# CITY OF ALBUQUERQUE

January 9, 2014

**Re: Eagle Crest Subdivision  
Grading and Drainage Plan  
Engineer's Stamp Date 12-21-13 (C18D064B)**

DRAWING NO.
DRB 3.0

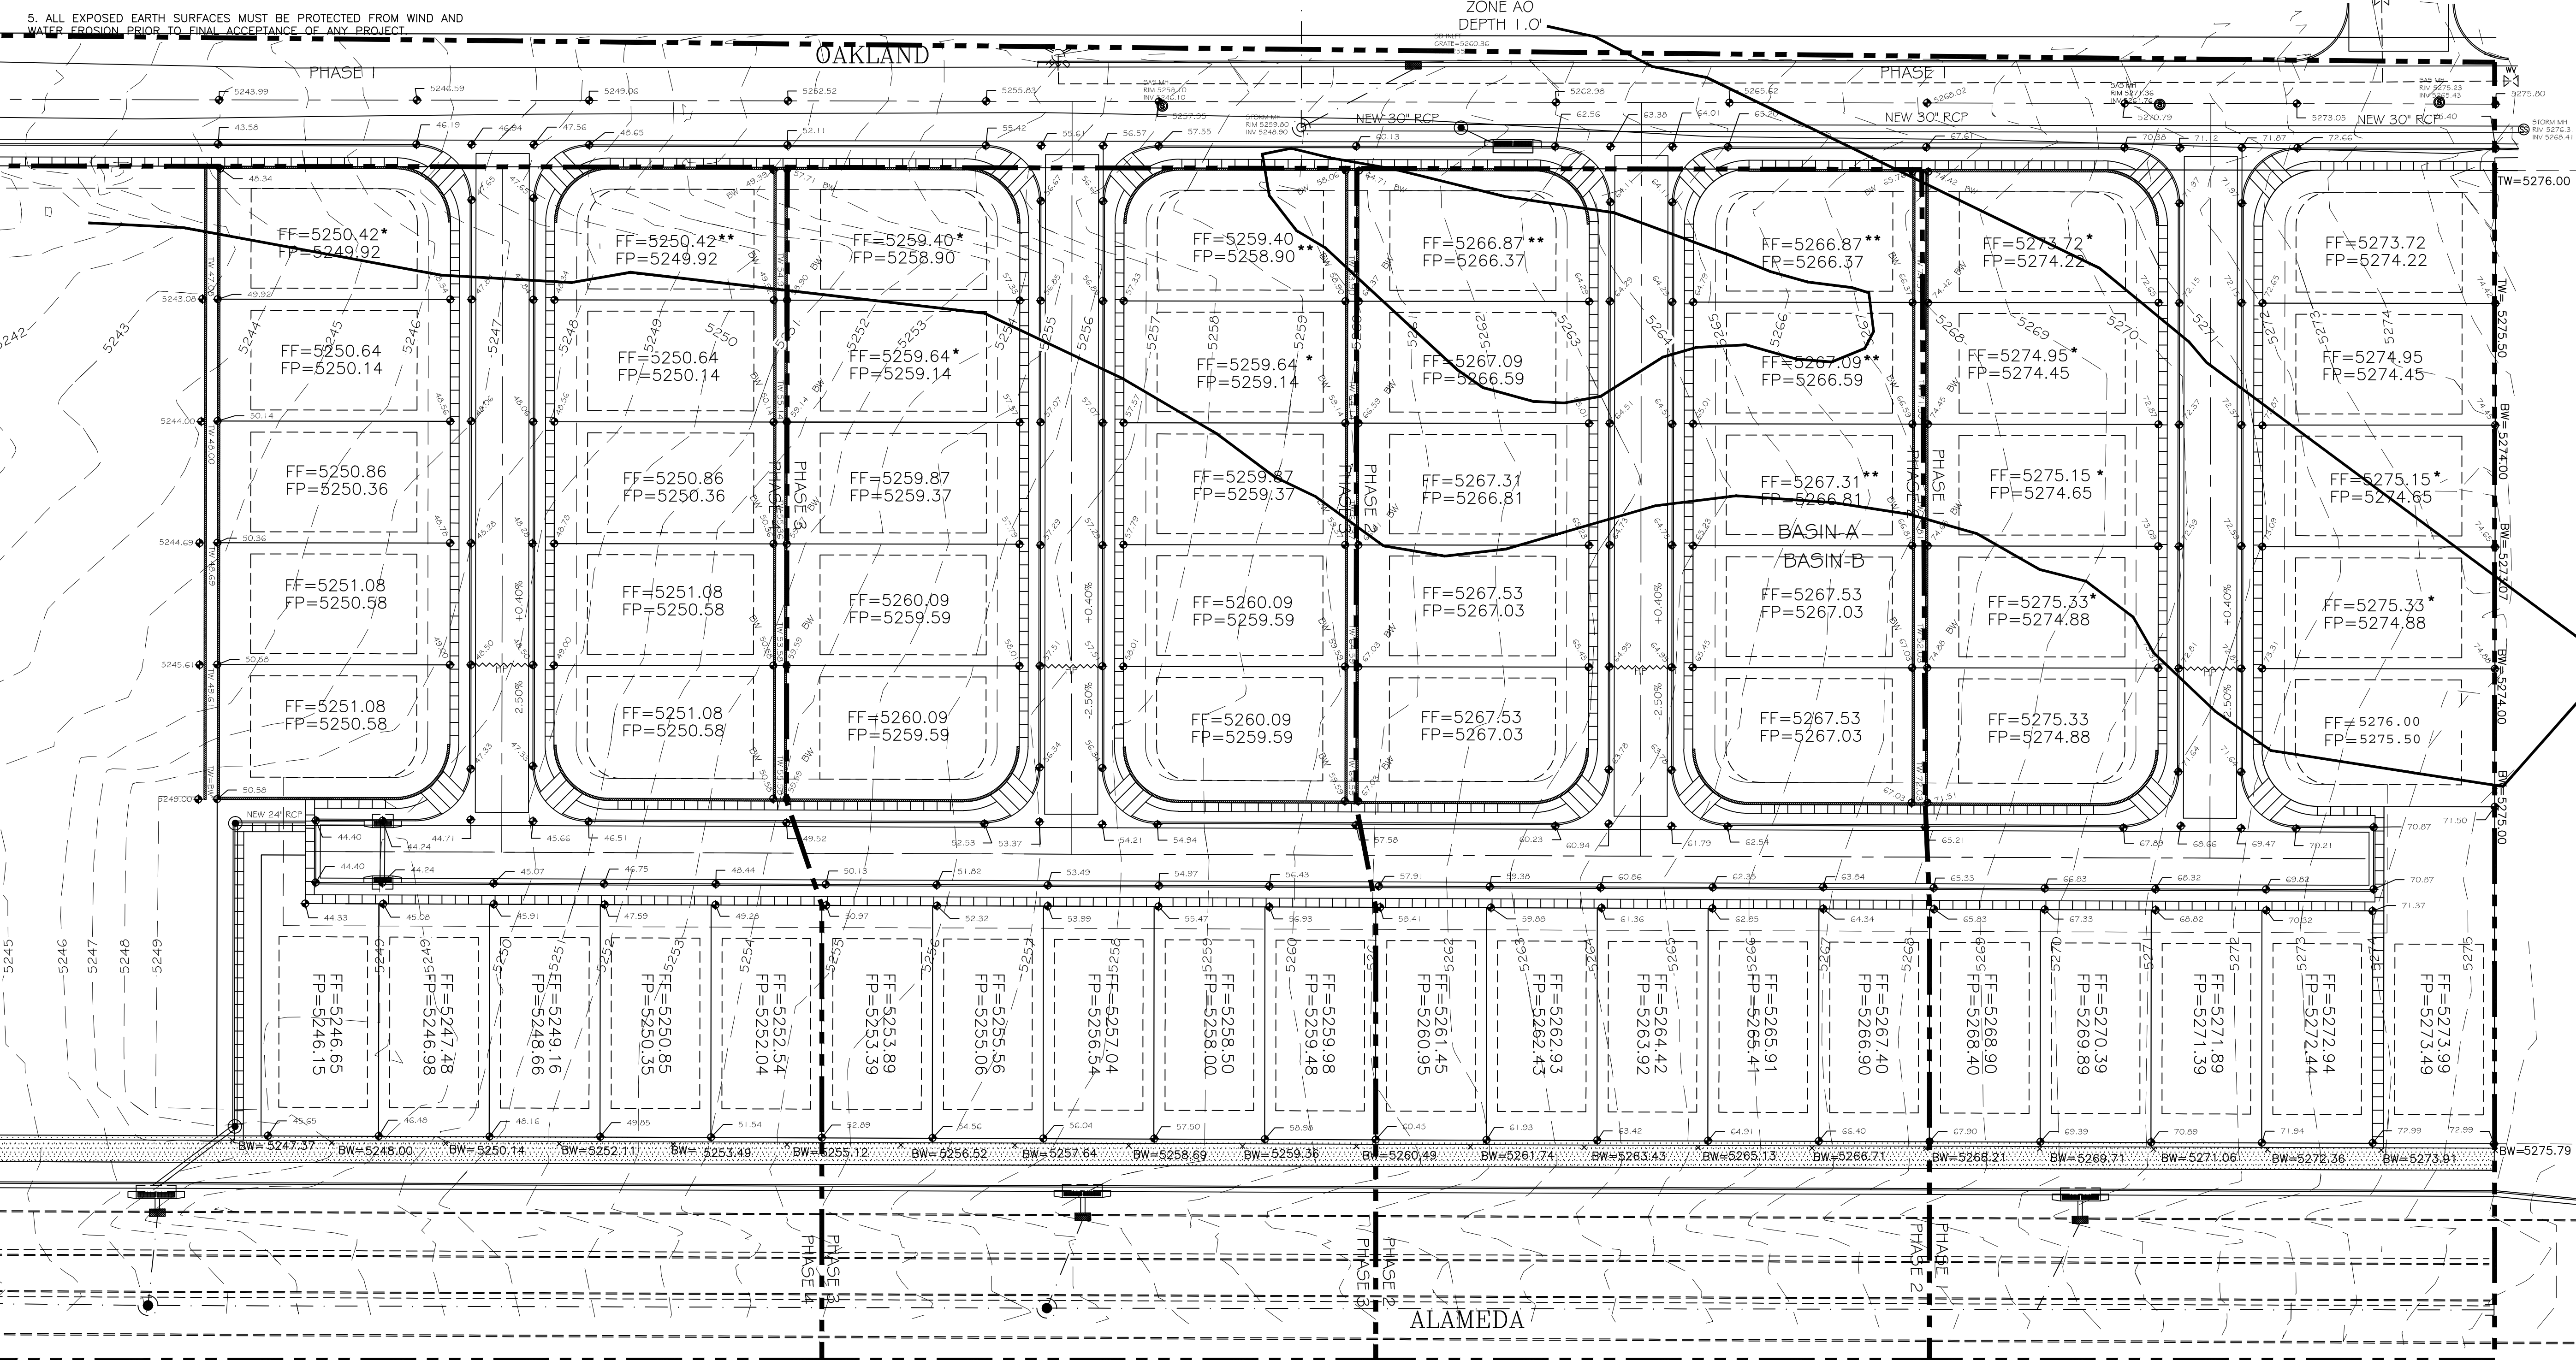
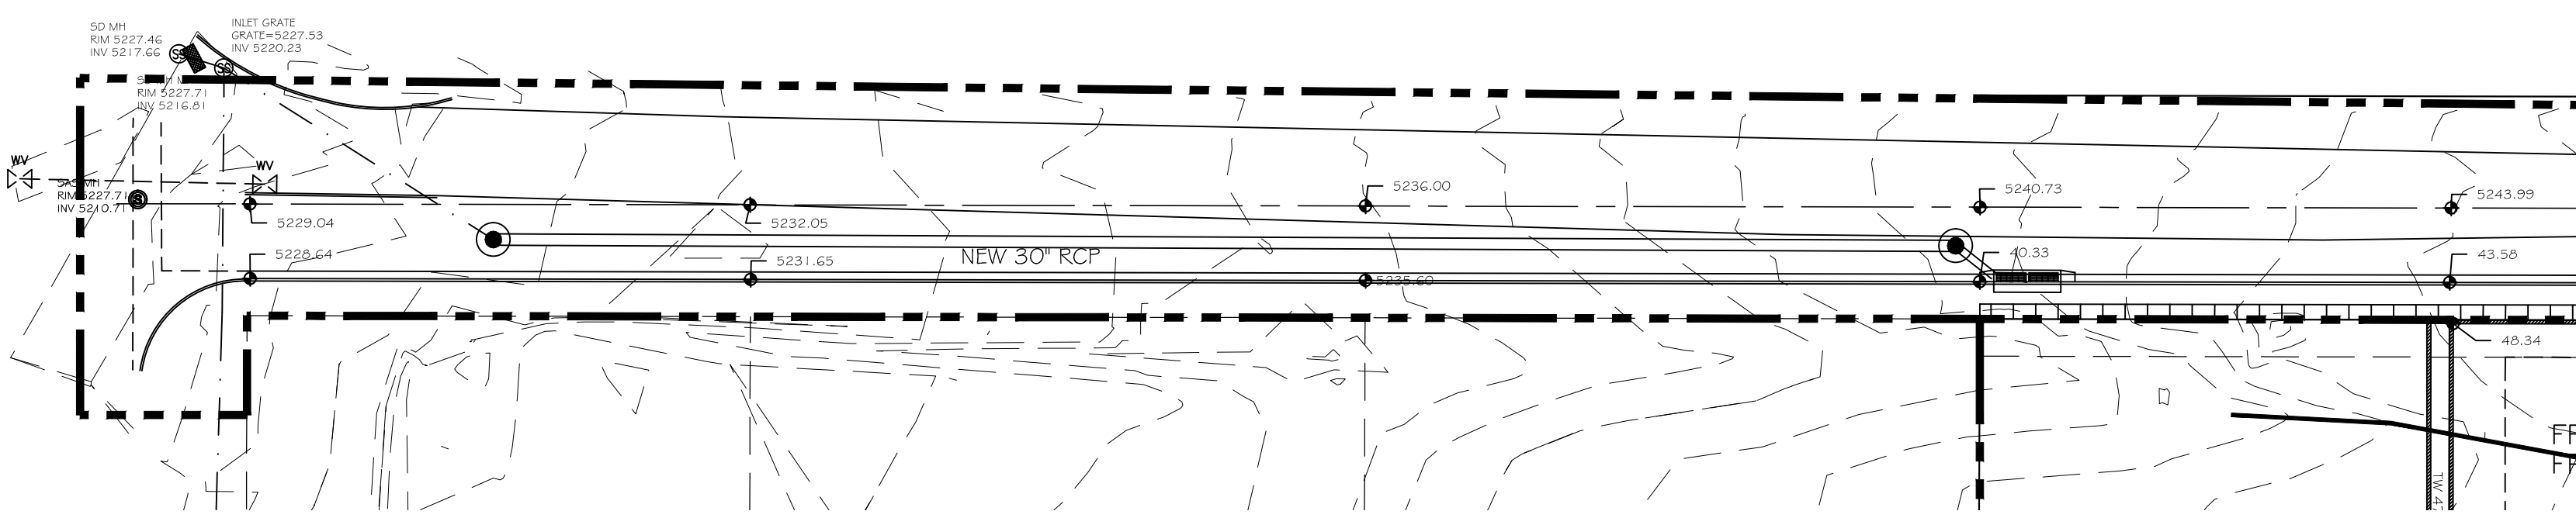
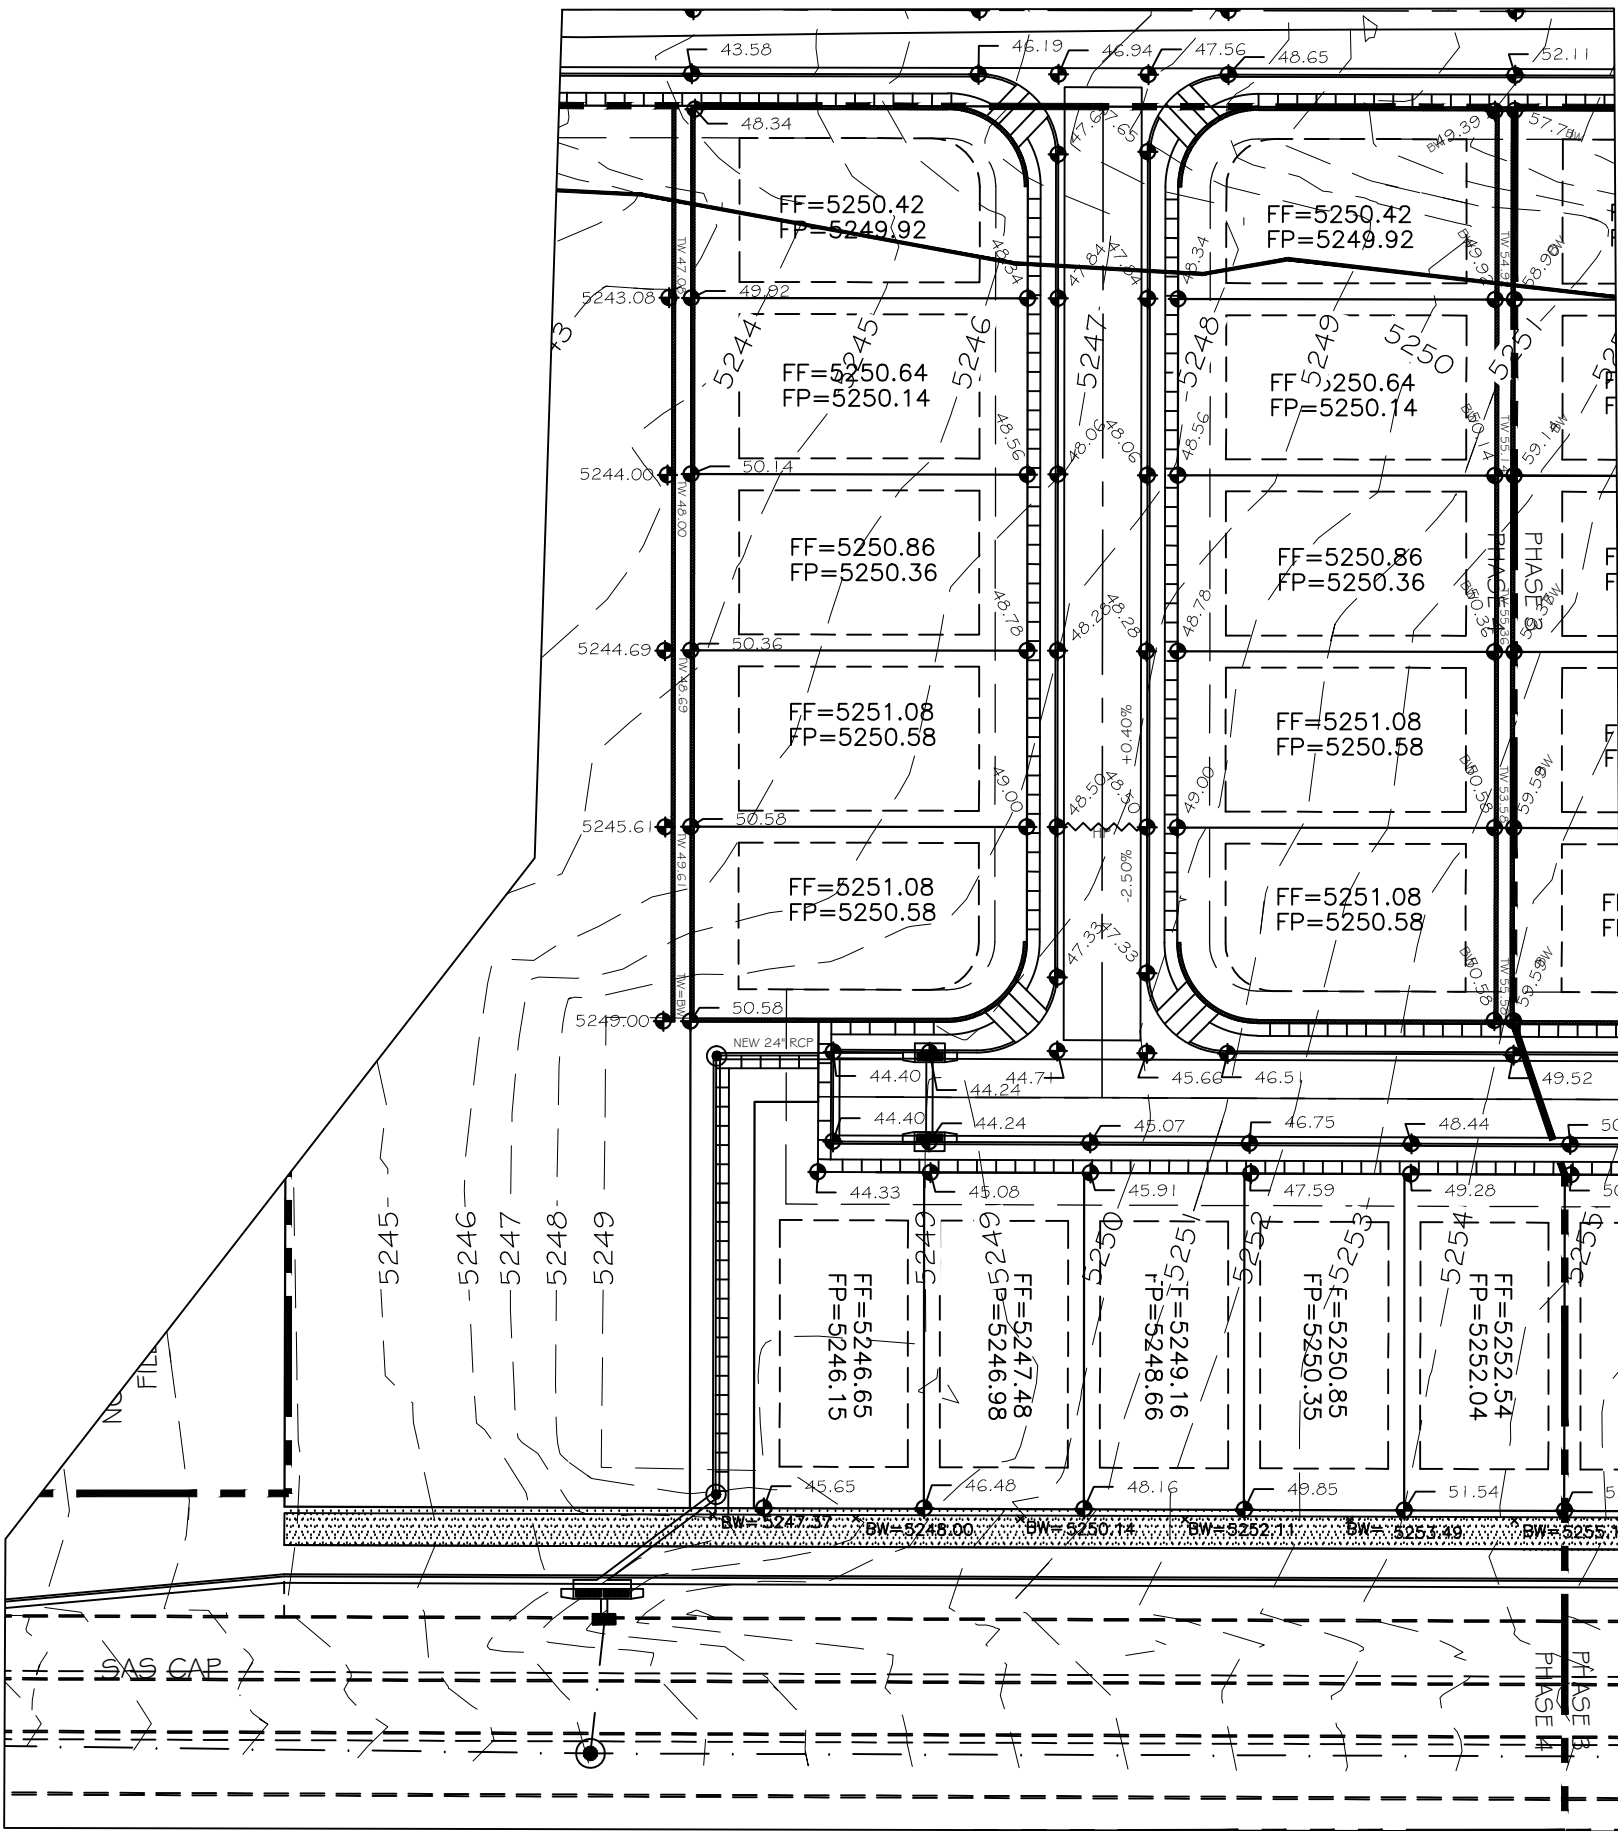
1. The horizontal location of the storm drain, west of the subdivision, should be located in the subdivision or in a public drainage easement. This easement can be placed in the proposed lot number 68 in the NW corner and enlarging lots 67-56 evenly.

2. A LOMR-F is not sufficient for this subdivision, a LOMR is required.
3. Make the proposed contour labels larger, and add existing contours with a lighter line.

4. A Flood plain permit is needed before any work commences.
5. The proposed 24" storm drain within Oakland does not appear to carry enough flow for the proposed 74.09 cfs. A quick calculation using Manning's equation proved that a 30" pipe would be the sufficient size.

6. Show the 24" wye just to the west of the commercial site from San Pedro. This wye should be the storm drain connection for the commercial site.
7. The proposed HDPE is not allowed in traffic right of ways, change to RCP.

8. For the proposed lots 39-55, it appears the FF is 2 feet above grade causing a 10% slope for the driveway and the backyard. This slope is not recommended for drives and yards. What is the reasoning for this height?

9. For the proposed lots 39-55, turn a block with openings facing out at least 6" above grade or at pad level, with fabric placed in front, to avoid erosion and sediment escaping out onto the sidewalk and road.
